Recommendation Report for Planning Permission for Works or Extension to a Dwelling

REF NO: LU/406/21/HH

LOCATION: 84 Oakcroft Gardens
Littlehampton
BN17 6LU

PROPOSAL: Proposed rear and side single storey extensions, alterations to existing first floor dormers and installation of 1 No. Velux rooflight.

Drawing Title: Proposed rear/side extension and side dormer
Planning & Building Regs

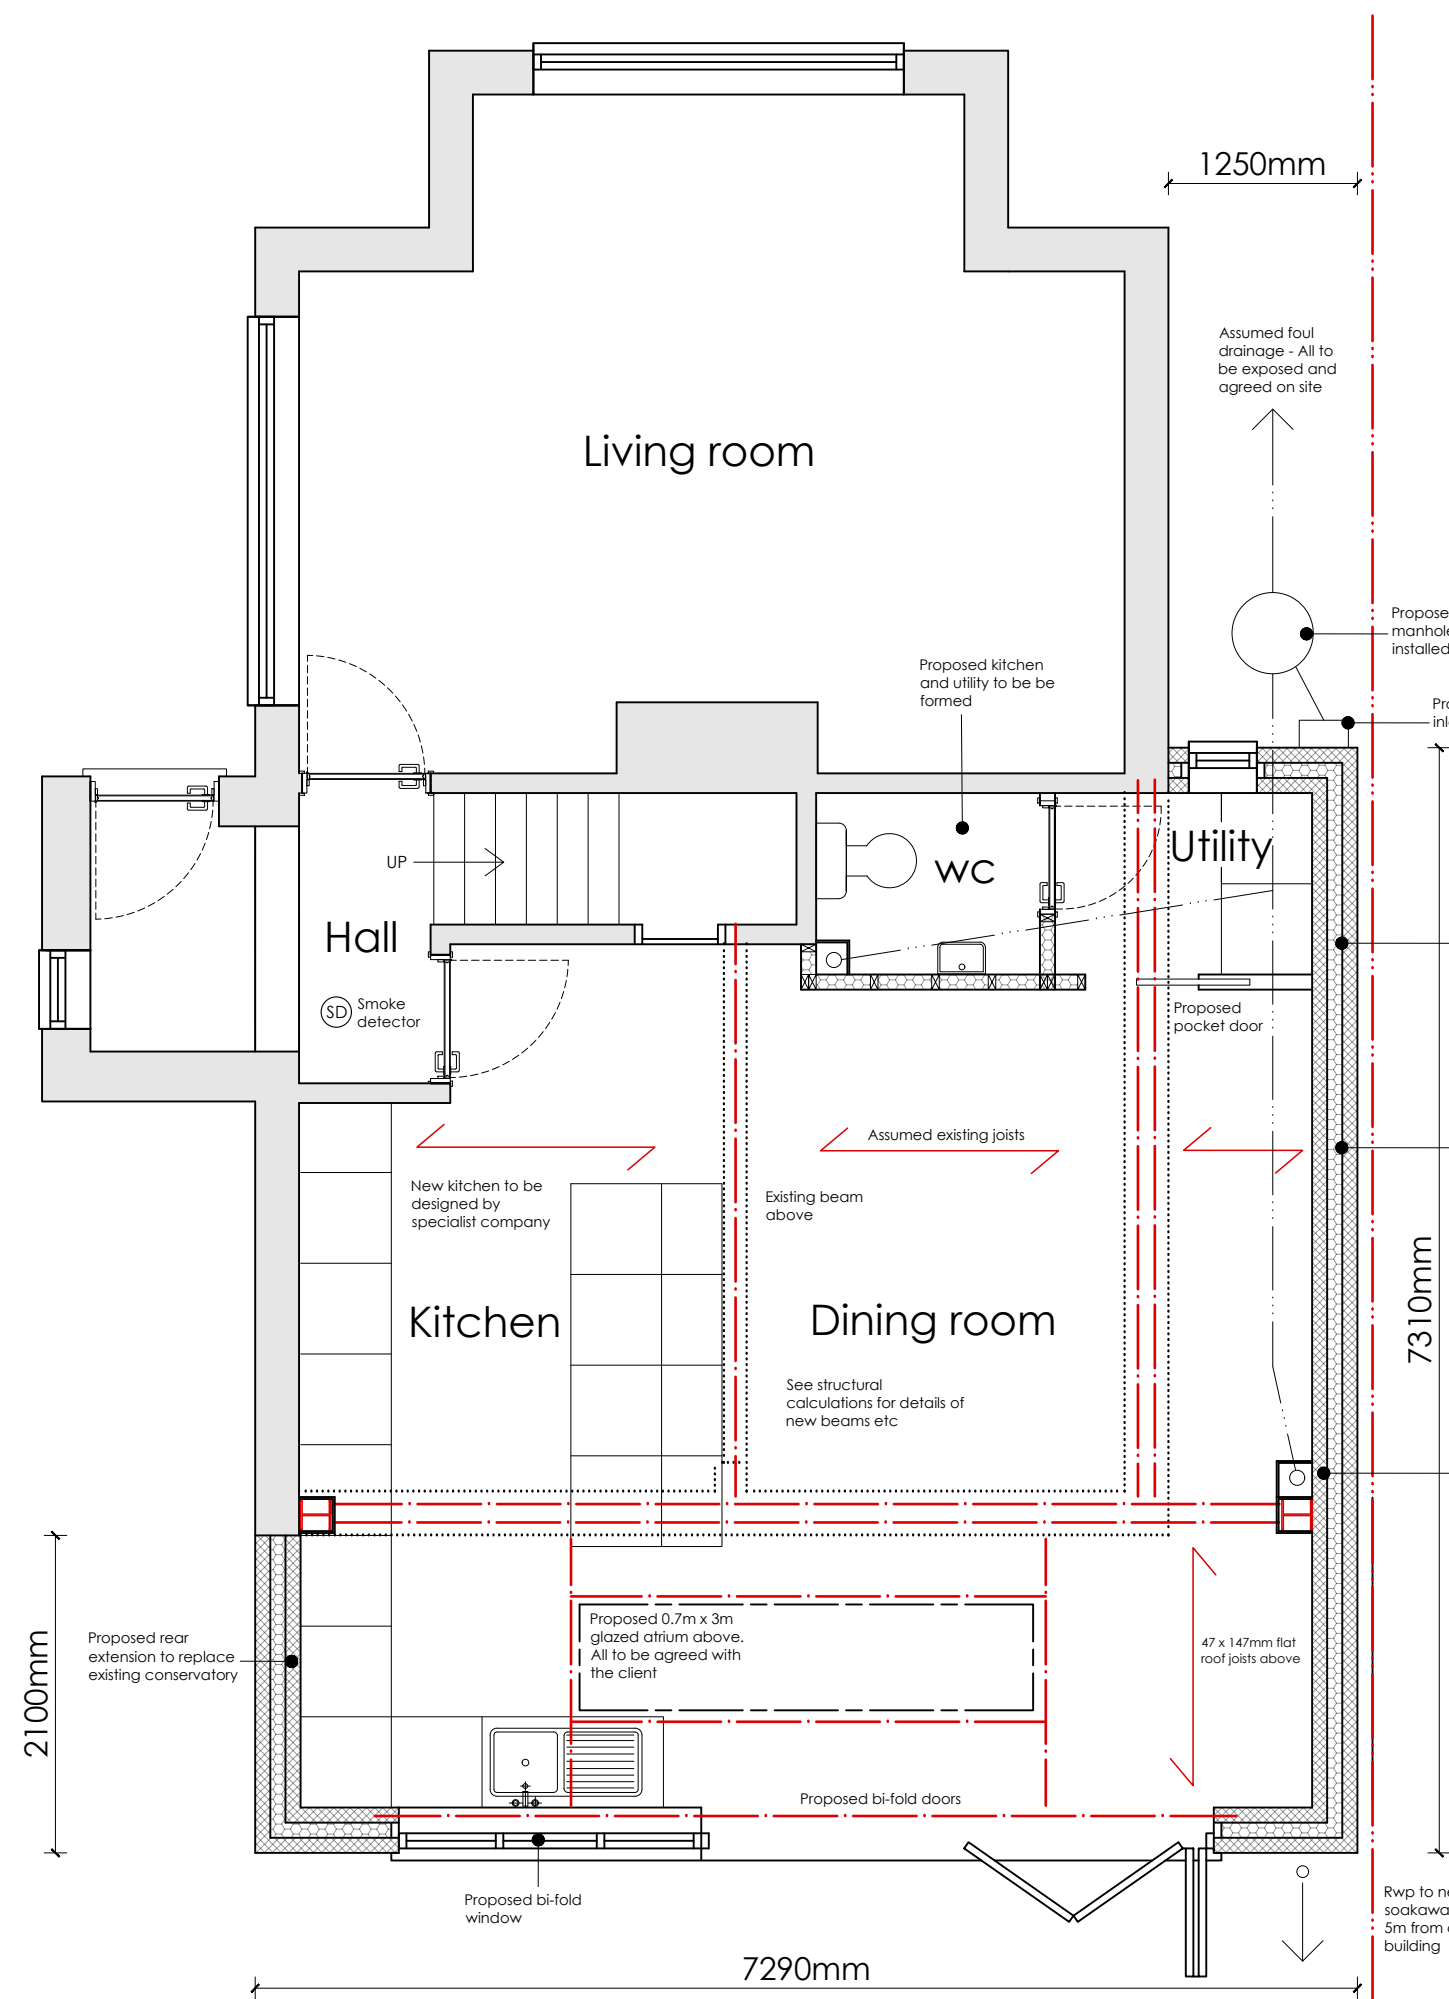
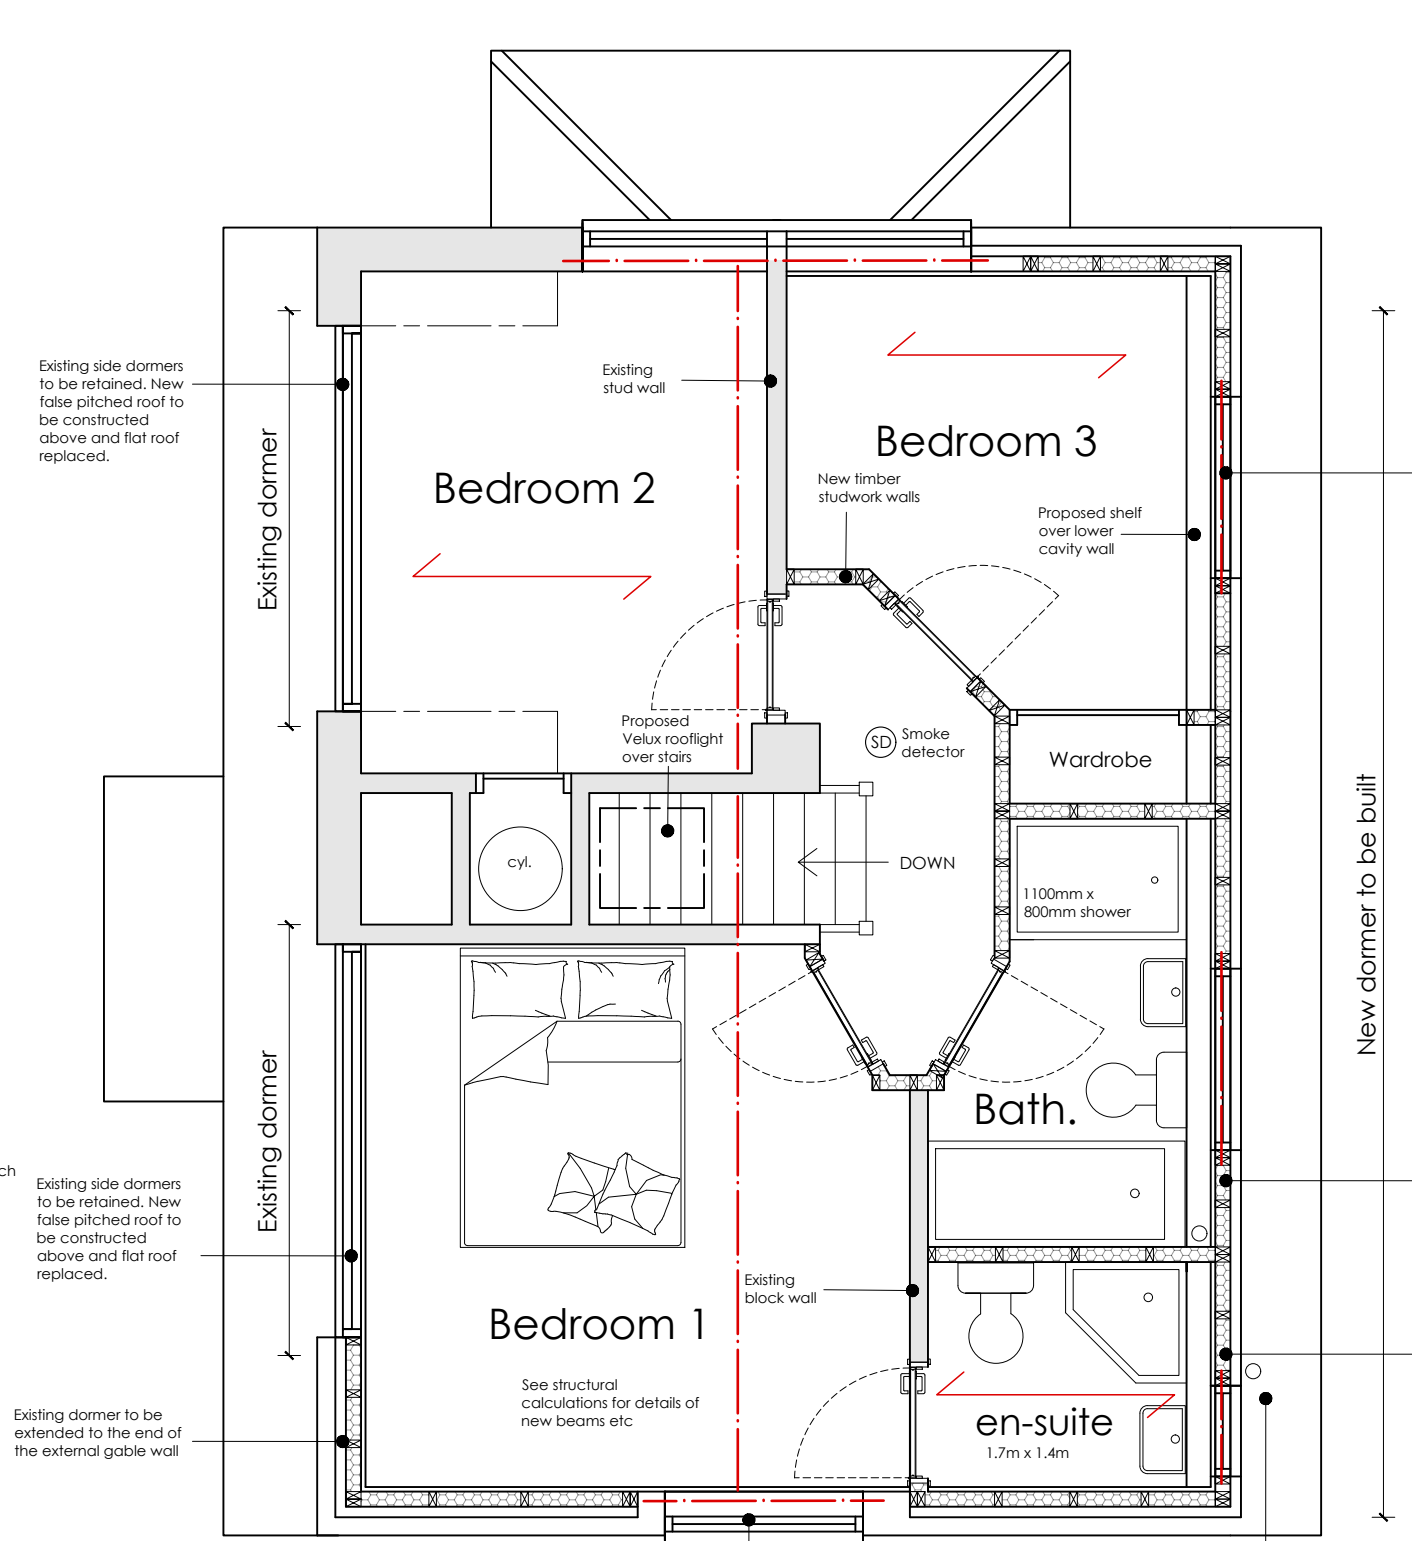
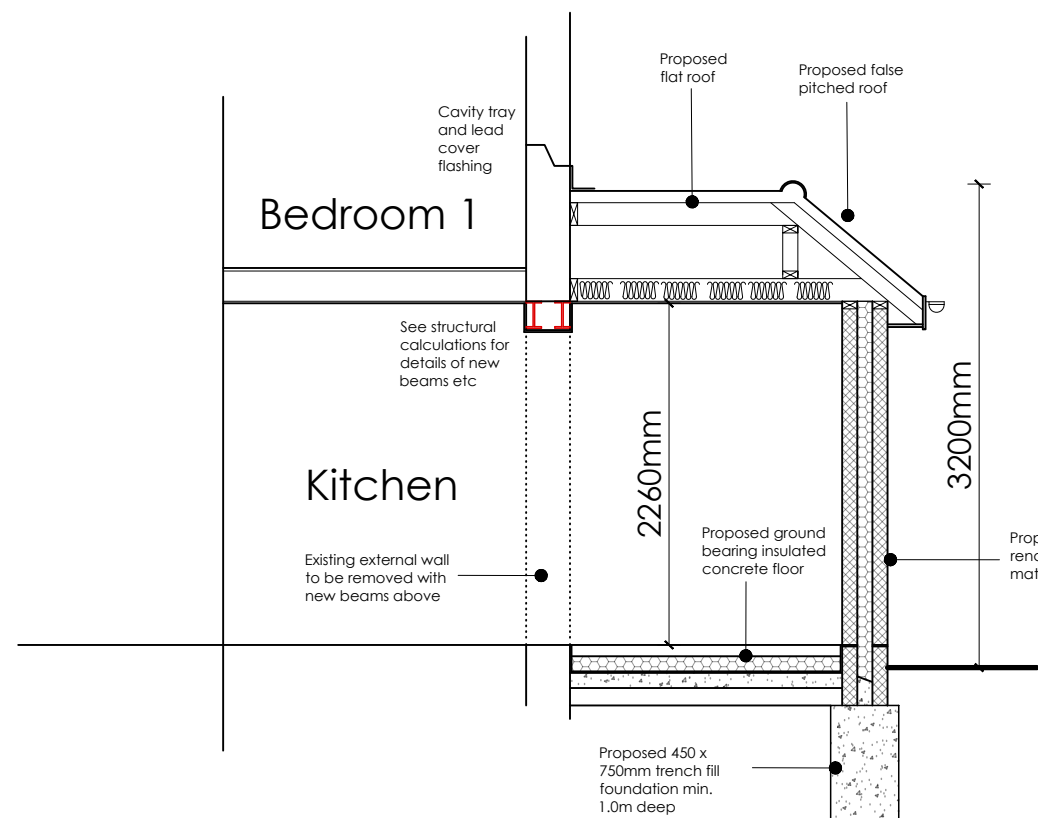
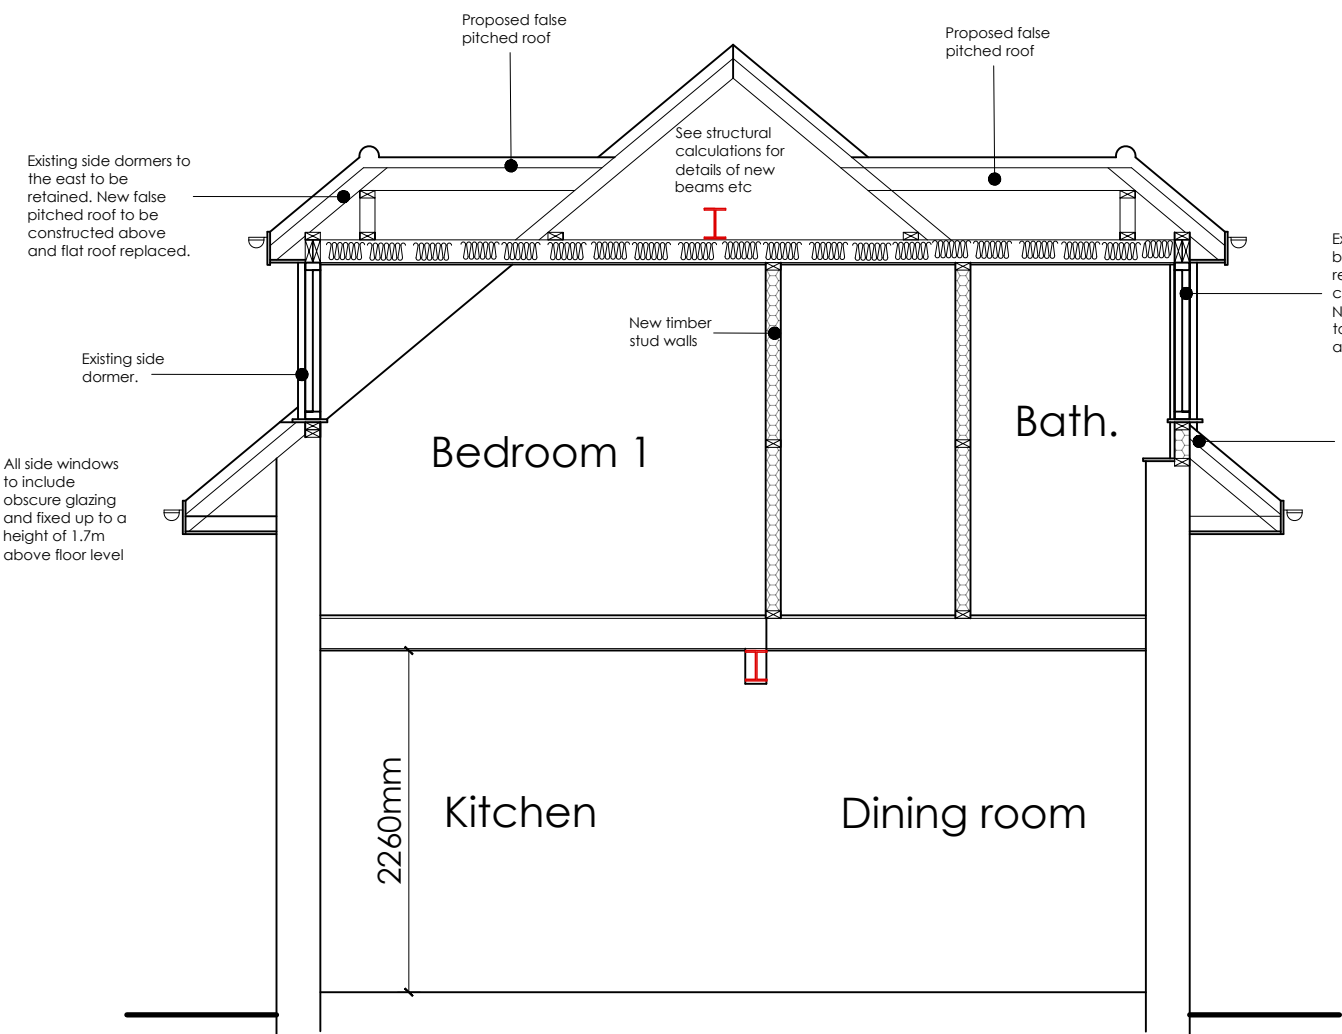
The single storey rear extension makes efficient use of the existing conservatory footprint but does extend 0.4m further to the rear of the property than the existing built form. This component extends 7.29m across the rear elevation from the east elevation to the western site boundary, maintaining the width of the existing conservatory/toilet. The rear extension features a false pitched roof design that meets the rear elevation at a height of approx. 2.9m, an approx. 0.1m increase. The rear extension incorporates matching materials to those found on the dwelling, is visually integrated and sympathetic to the host dwelling in terms of form, scale and design. There are no views of this component from the street.

The single storey side extension is 1.25m in width, projecting off of the western elevation and meeting the western site boundary. The side extension is 7.31m in depth, extending down the side (western) elevation, meeting the proposed rear extension. This component features a flat roof design at approx. 2.6m in height and matching materials to those found on the existing dwelling. It is predominantly obscured from view by the host dwelling and neighbour dwelling to the west. There are potential views from the street but the scale and design are appropriate and do not give rise to adverse visual impacts on the street scene.

The alterations to the flat roof dormers include false pitched roof designs and replacement of 2 No. western elevation dormers with 1 No. large dormer. Proposed alteration of the dormers to feature false pitched roofs is considered a complimentary design choice being sympathetic to the existing roof pitch and furthering visual integration. The 2 No. eastern dormers do not give rise to any adverse visual

impacts on the street scene. The removal of the western elevation dormers and replacement with one large dormer is not considered sympathetic to the host dwelling in terms of scale. It is acceptable as it is visually integrated through design, choice of materials and not being out of character within its locality as the locality is populated by large first floor dormers. The western elevation is partially obscured by the neighbour dwelling to the west and as such, has reduced visual impacts on the street scene.

The rear extension includes rear glass doors that look to the rear of the property, retaining 11m to the rear boundary. The scale of the rear extension is moderate and makes efficient use of the existing conservatories built form. Section M of the Arun Design guide sets out the 45 & 60 degree sightline rule when concerning rear extensions. The rear extension component does not obstruct 60 degree sightlines from rear the rear viewpoints of any neighbouring dwellings. The rear extension also, does not obstruct neighbouring 45 degree light access lines. This component does not give rise to any adverse impacts by way of overbearing, overshadowing or overlooking.

The side extension meets the western site boundary. This is in close proximity to the eastern elevation of the neighbour dwelling 83 Oakcroft Gardens. There is a path extending down the eastern elevation of 83 Oakcroft Gardens and 2 No. side facing windows that look over this path and at the western elevation of 84 Oakcroft gardens. The side extension will extend approx. 3m alongside this pathway but not significantly adversely impact the viewpoints from these side windows. The viewpoints these neighbouring windows currently possess are already met by the Western elevation of the host dwelling and provide lookout to little more. The larger of the 2 No. windows on the east elevation of 83 Oakcroft Gardens is closer to the front of the dwelling and will still retain the partial existing view that is able to look past the front of 84 Oakcroft Gardens at an angle to see the street. The side extension may have some minor adverse impact by way of overbearing on the eastern elevation of 83 Oakcroft Gardens however, it will not give rise to any significant loss of light or obstruct any significant sightlines for these neighbouring windows further than what is already achieved by the existing host dwelling. This component is acceptable.

The new west facing dormer has been proposed to have obscure glazed windows that are fixed shut up to 1.7m. This is appropriate due to the sightlines they provide, looking out onto the side of the neighbouring properties. As such, in concurrence with the submitted plans, these have been conditioned to be obscure glazed and fixed shut up to 1.7m

Reason: For the avoidance of doubt and in the interests of amenity and the environment in accordance with policy D DM1 of the Arun Local Plan.
- 3 The proposed west facing dormer in this application hereby approved, shall have non-opening windows below 1.7m above floor level. The dormer windows will also be fully obscured prior to the first use of the rooms.
